LAND TECHNOLOGIES, INC.

Response to Comments

Project Name: Quality Auto Center
 Project File Number: PA22-005
 Review Completion: March 15, 2022

Quality Auto Center
 LANDSCAPE PLAN
 PA 22005

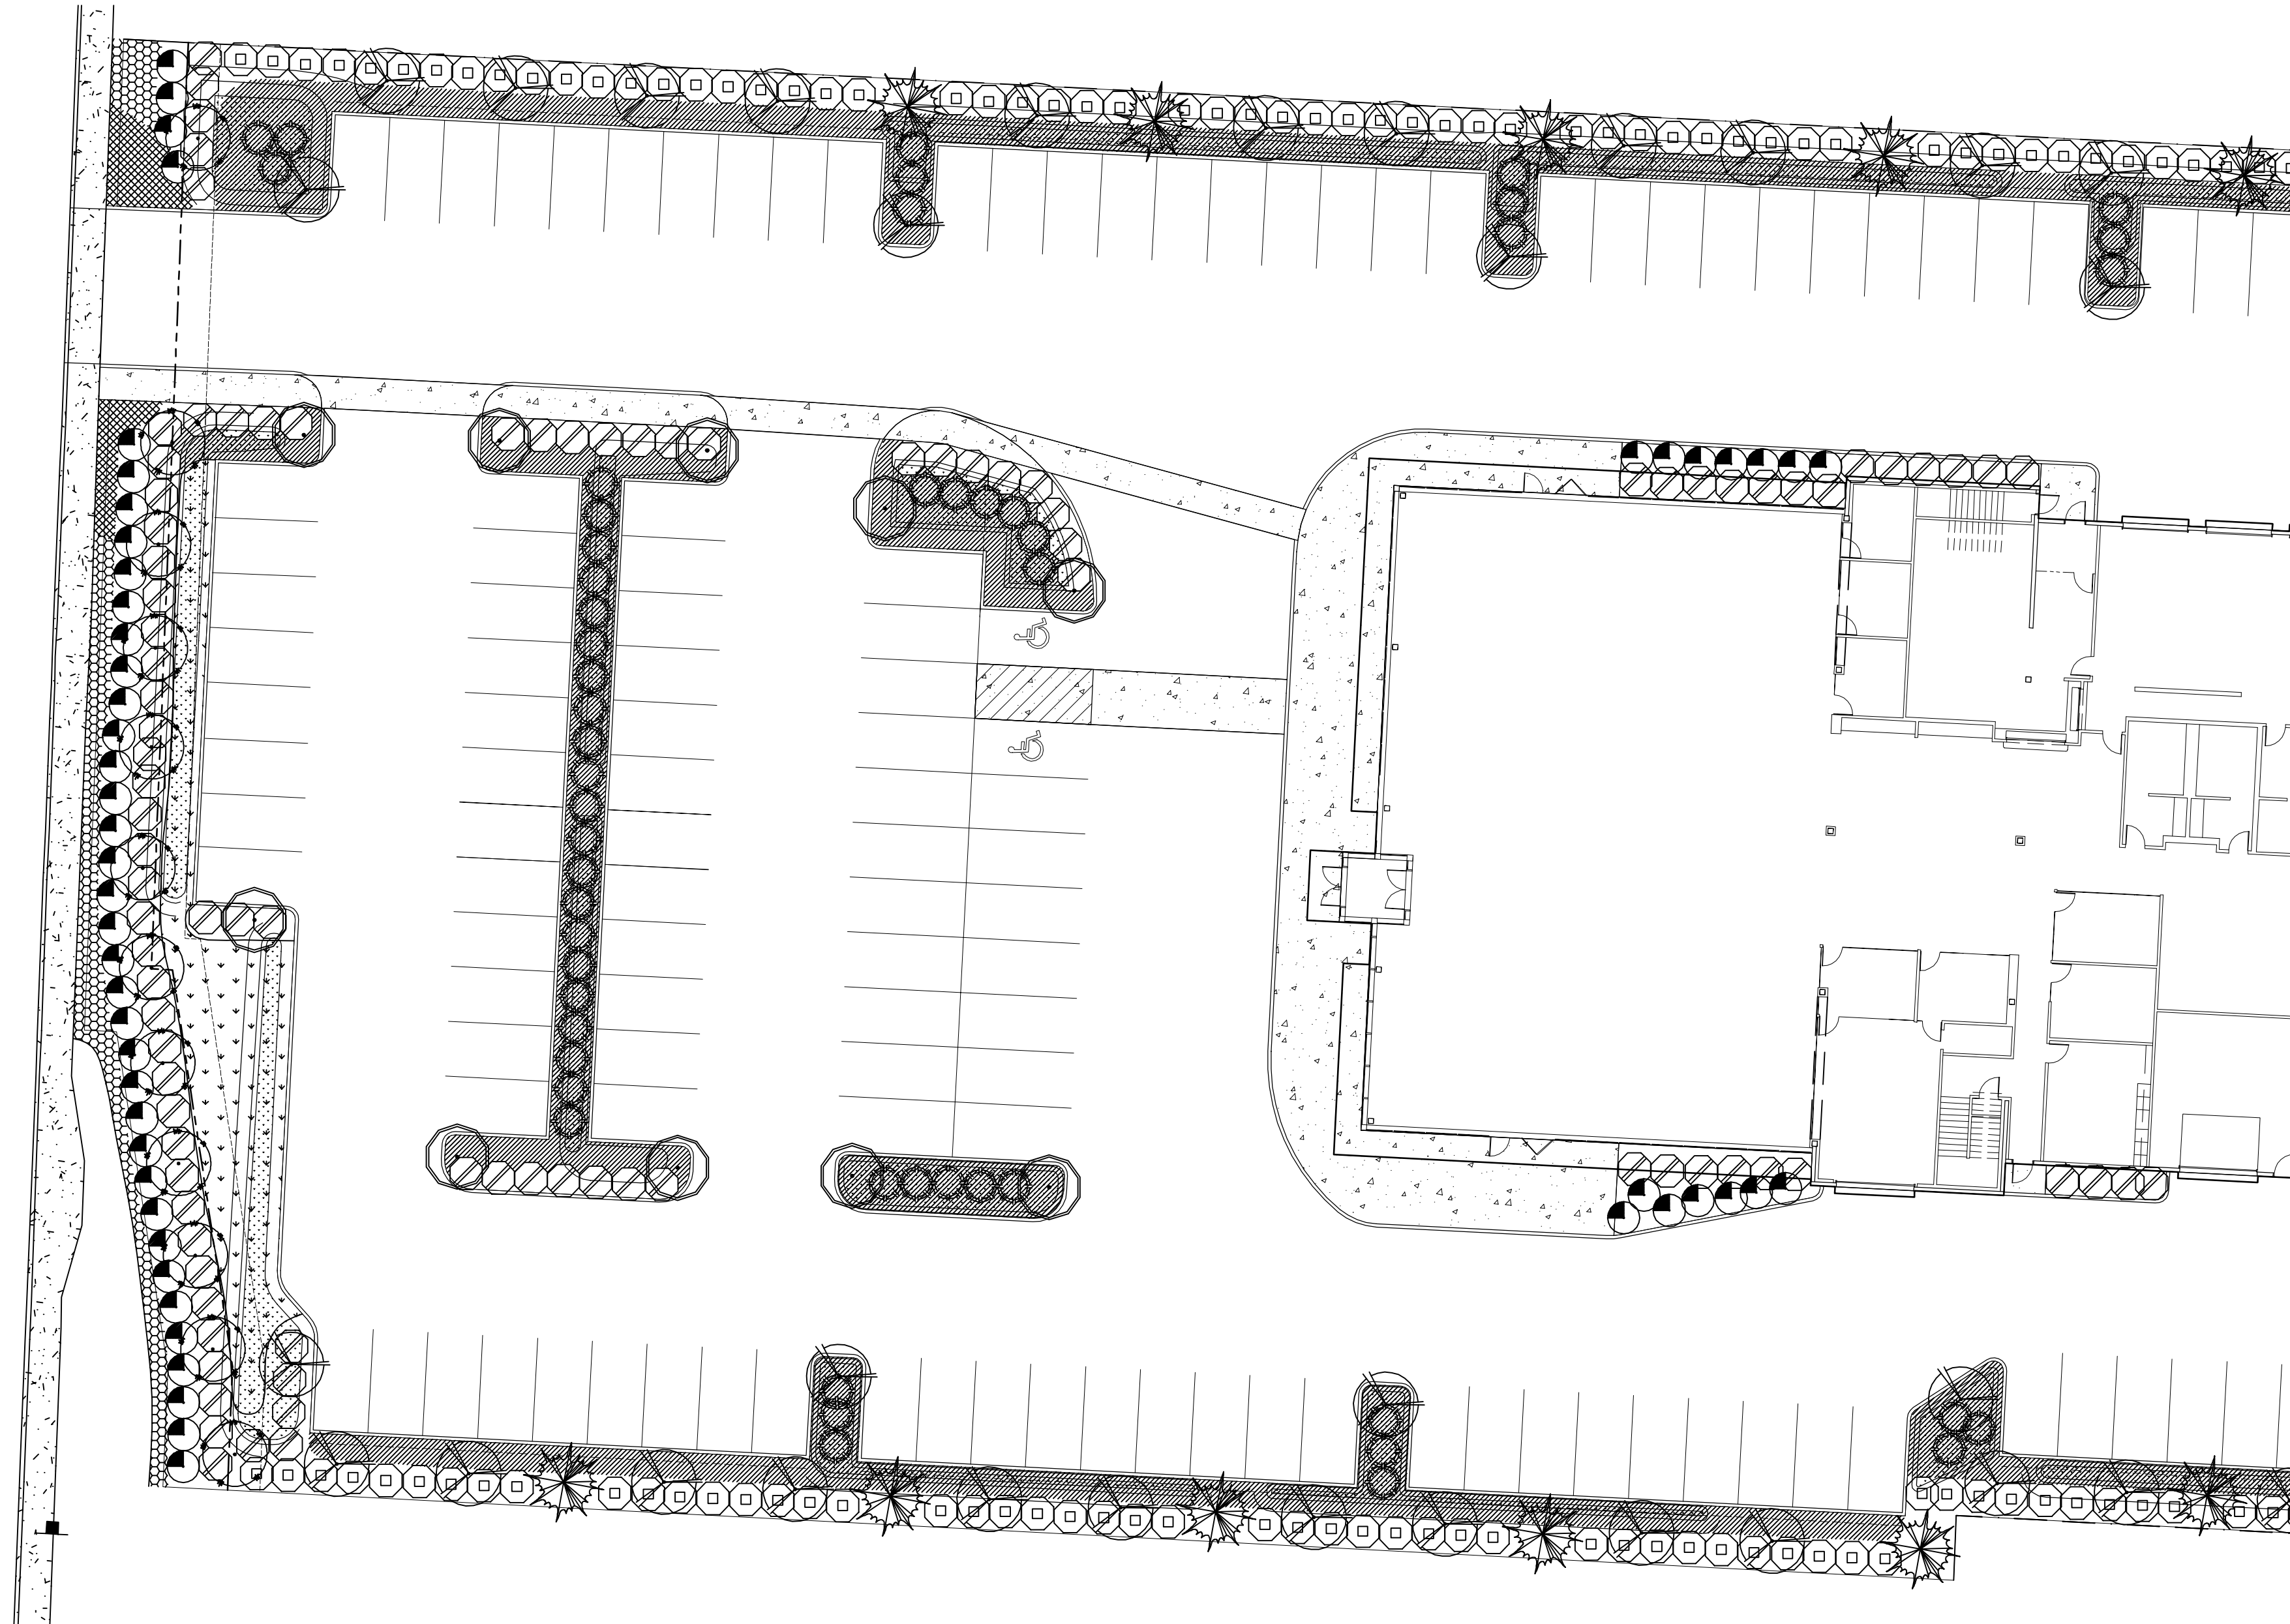
<p>5. Prior to civil construction plan approval, a detailed landscaping plan depicting all of the applicable elements outlined in MMC 22C.120.030 will be required to be approved. Below are specific design requirements outlined in MMC Chapter 22C.120 and in MMC 22C.020.250(4). The landscape architect shall be required to amend the preliminary landscape plan to ensure compliance with the specific type of landscape buffer requirement:</p> <p>a. The applicant shall be required to demonstrate that landscaping can be planted and thrive within the proposed bioretention cells. Staff</p>	<p>a. Most of the buffer plantings are located on the sides of the bioretention cells. Plantings located within the cells are capable of handling the occasional inundation. Biocells have been used numerous times to provide landscaping—one</p>

CITY COMMENTS	LAND TECH RESPONSE
<p>has concerns about utilizing the bioretention cells to satisfy the required landscape buffers.</p> <p>b. Identify compliance with the water conservation measures shall be applied as outlined in MMC 22C.120.050.</p> <p>c. Because the proposed auto dealership is not located along the street edge, enhanced landscaping shall be required within the 15' L3 buffer along Smokey Point Boulevard, in order to create an attractive street edge. The landscape architect shall propose enhanced landscape materials such as boulders, or other decorative materials that would enhance the streetscape.</p> <p>d. The landscape architect shall be required to demonstrate compliance with the buffer planting requirements outlined in MMC Chapter 22C.120 and the general planting guidelines outlined in the Administrative Landscaping Guidelines. It does not appear that the perimeter landscaping and landscape islands comply with the L4 standards.</p> <p>e. The following landscape buffers are required:</p> <ul style="list-style-type: none"> . A 15' L3 landscape buffer is required between vehicle display areas and Smokey Point Boulevard. . In addition to the hardscaped screening requirements for garbage collection, dumpsters and recycling areas, a minimum 5' L2 screen shall be provided around the perimeter. <p>f. 10% of the required parking areas shall be landscaped with L4</p>	<p>the oldest examples is the Shell Station in Lakewood. We can provide photos if needed.</p> <p>b. To comply with the water conservation measures I have removed the majority of lawn areas. Plantings are chosen that are compatible with the local climate.</p> <p>c. Perennial flower plantings and annual color spots have been added to the streetscape providing the enhanced landscape.</p> <p>d. Buffers have been corrected to meet the requirements</p> <p>e. Trees were added to meet the buffer requirements.</p> <p>A 5' planting buffer is provided around the dumpster.</p>

PRELIMINARY SITE PLAN

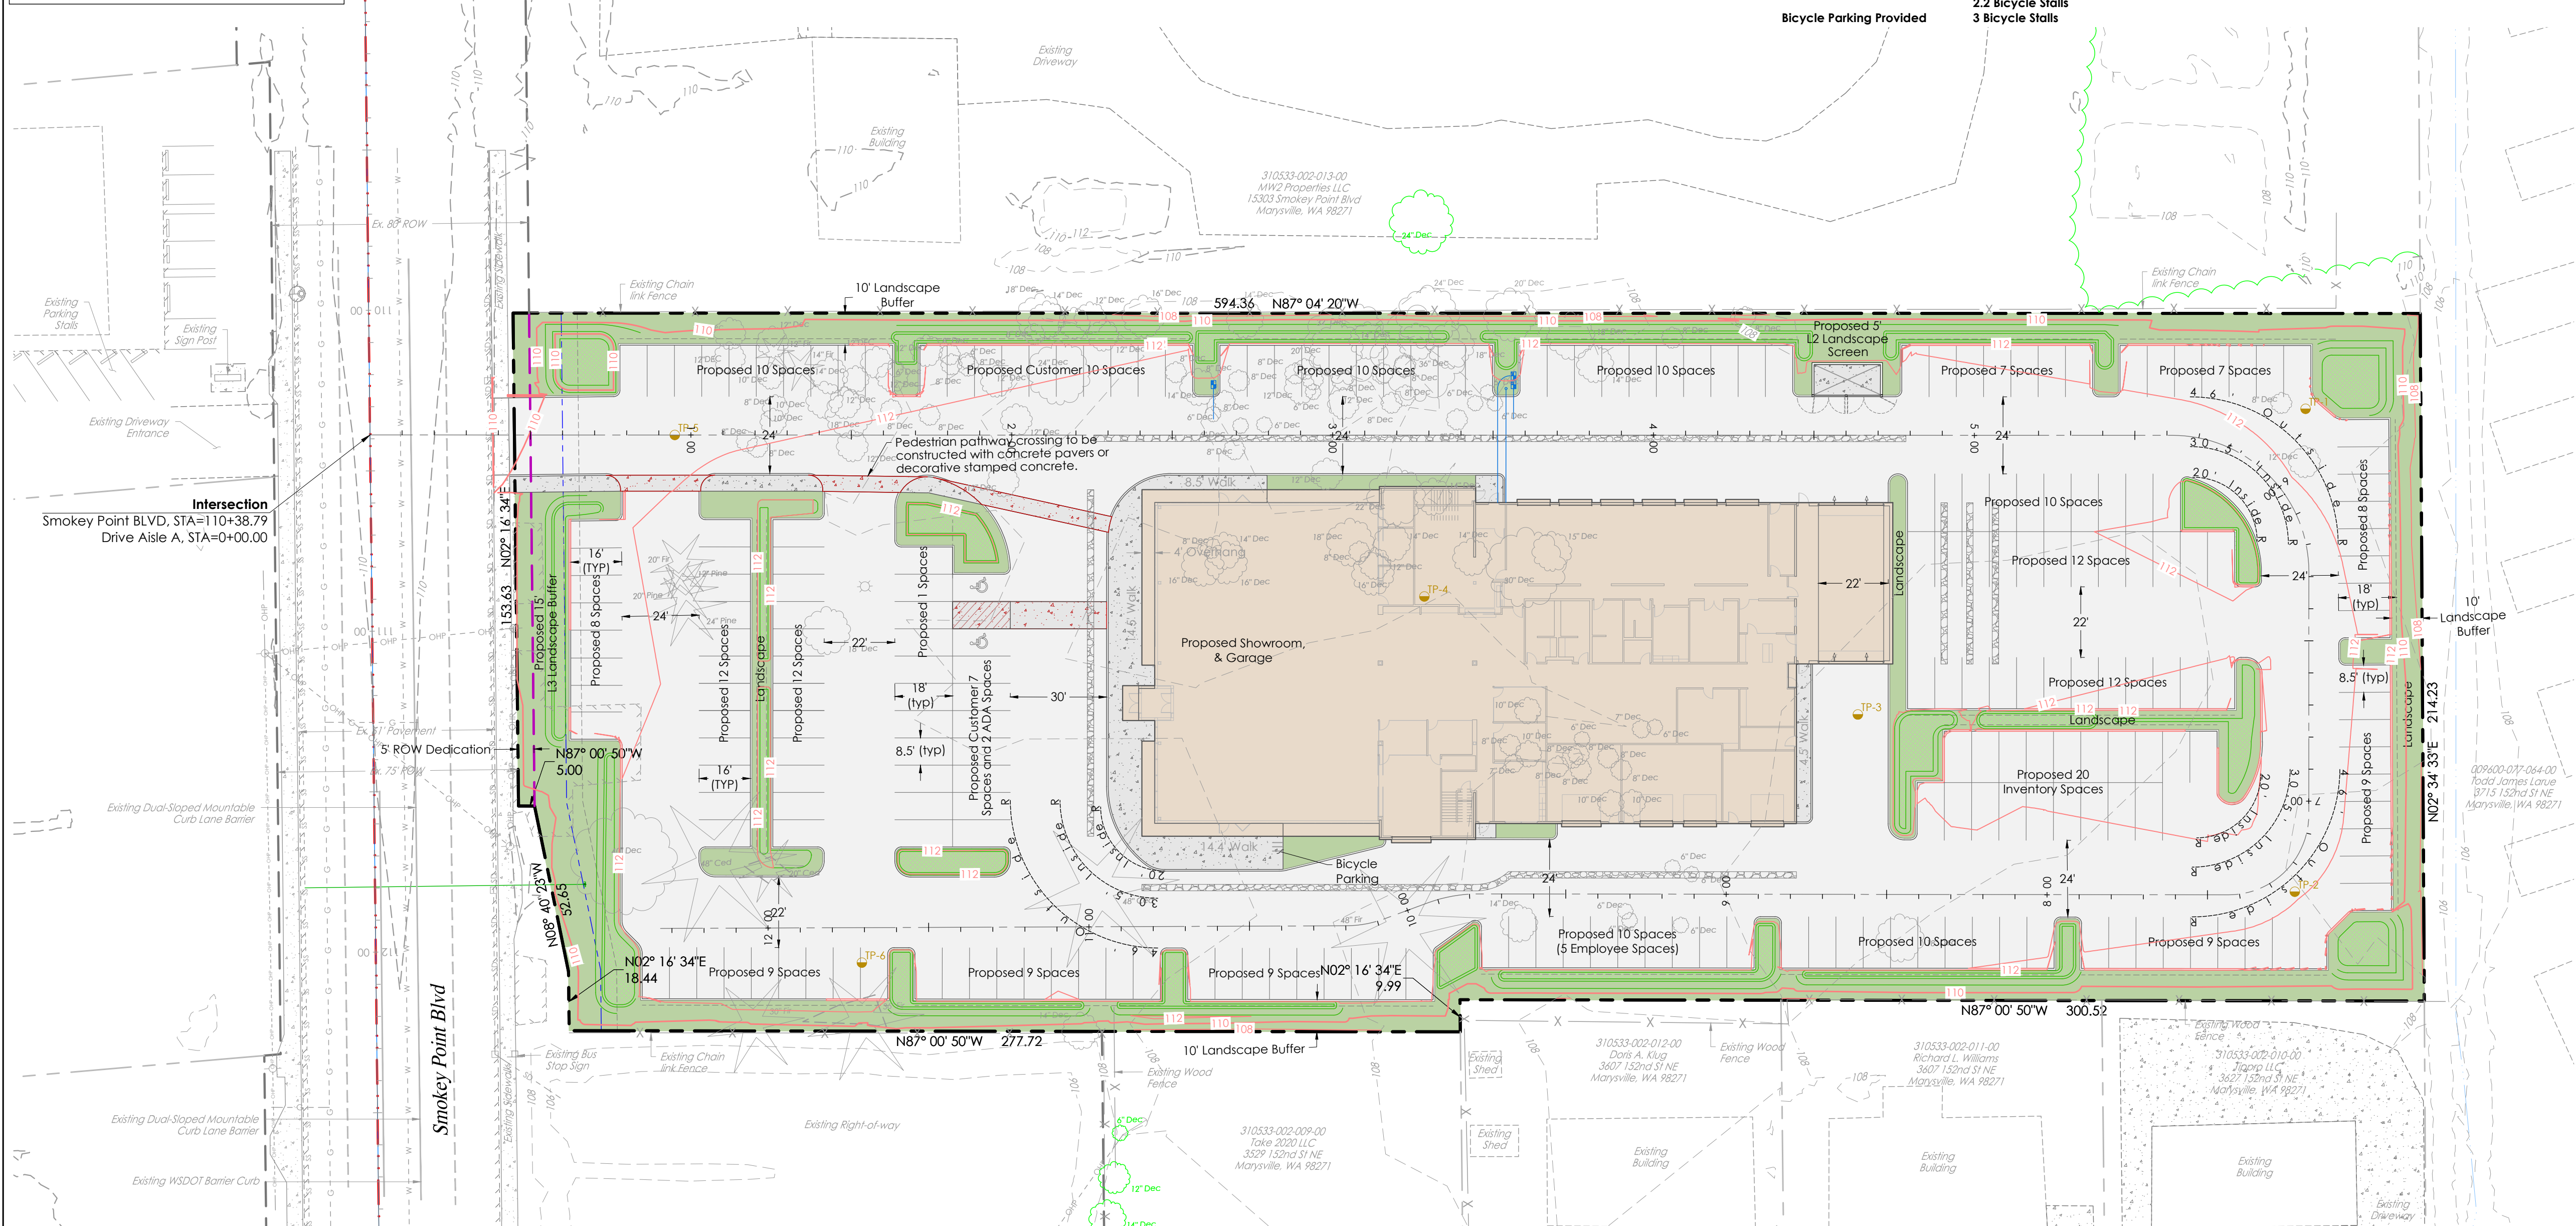
CITY COMMENTS	LAND TECH RESPONSE
Community Development: Reviewer: Chris Holland, Planning Manager	
1. Provide File Number PA22005 on all future site, civil and landscape plan submittals.	Added file number to Landscape and Irrigation Plans
2. After conducting a site visit and reviewing the Critical Areas Report, prepared by Sewall Wetland Consulting, dated January 10, 2022, the Planning Division concurs that there are no regulated critical areas located on-site. The linear ditch located along the eastern property boundary is considered a "Water of the US" as it is hydrologically connected to a fish bearing stream. Any proposed alterations to the ditch will require a permit from the US Army Corps of Engineers.	Thank you.
3. Sheet P1 shall be amended, as follows (see attached redlines):

CITY COMMENTS	LAND TECH RESPONSE
<p>a. The pedestrian connection shall be relocated to align with the front entry to the showroom to the sidewalk. Pursuant to MMC 22C.130.050(5)(c), the pedestrian pathway shall be constructed with decorative concrete and physically separated from vehicle traffic and maneuvering areas.</p> <p>A minimum 5' landscape islands shall be provided on either side of the pedestrian pathway as it traverses through the proposed parking spaces and/or inventory lot.</p> <p>b. Provide turning radii, demonstrating compliance with the following: Turning radii- 20' (inside) Turning radii (fire/solid waste) - 30.5' (inside) 46' (outside);</p> <p>c. Amend SIGNS language to read as follows: All signs <u>shall</u> are to comply with MMC Chapter 22C.160 Signs22C.160.160(1).</p> <p>d. Under NOTES, remove notes d, e, f and g, and add the following notes: Prior to civil construction plan approval, the applicant shall be required to demonstrate compliance with the applicable landscaping standards outlined in MMC 22C.020.250(4). Prior to building permit issuance, the applicant shall be required to demonstrate compliance with the Site Design Utilizing Crime Prevention</p>	<p>a.) pedestrian connection cannot be made at midpoint of the property frontage and have the required fill material to provide separation from groundwater. The Elevations here do not work. 130.050(5)(c) requires that pedestrians and wheelchairs easily gain access from Public Streets... to building entrances through use of raised concrete or pervious pavement sidewalks..., <u>or</u> pedestrian paths which are physically separated from vehicle traffic...</p> <p>We are proposing the use of pervious pavement dyed brick red and not optioning for the "or" separated path.</p> <p>We do provide landscape on the side of the walk as it crosses landscape areas and do not see in code where the 5' landscape islands on either side of the path are required. <i>Five foot landscape islands are not included in MMC 22C.130.050(5)(c)</i>.</p> <p>b.) turning radii are included through the fire lane route to show compliance with the standards. This is located on Sheet P1- Site Plan.</p> <p>c.) Notes updated to read Chapter 22C.160 <u>SIGNS</u></p> <p>d.) All notes have been updated as items e.) through n.).</p>
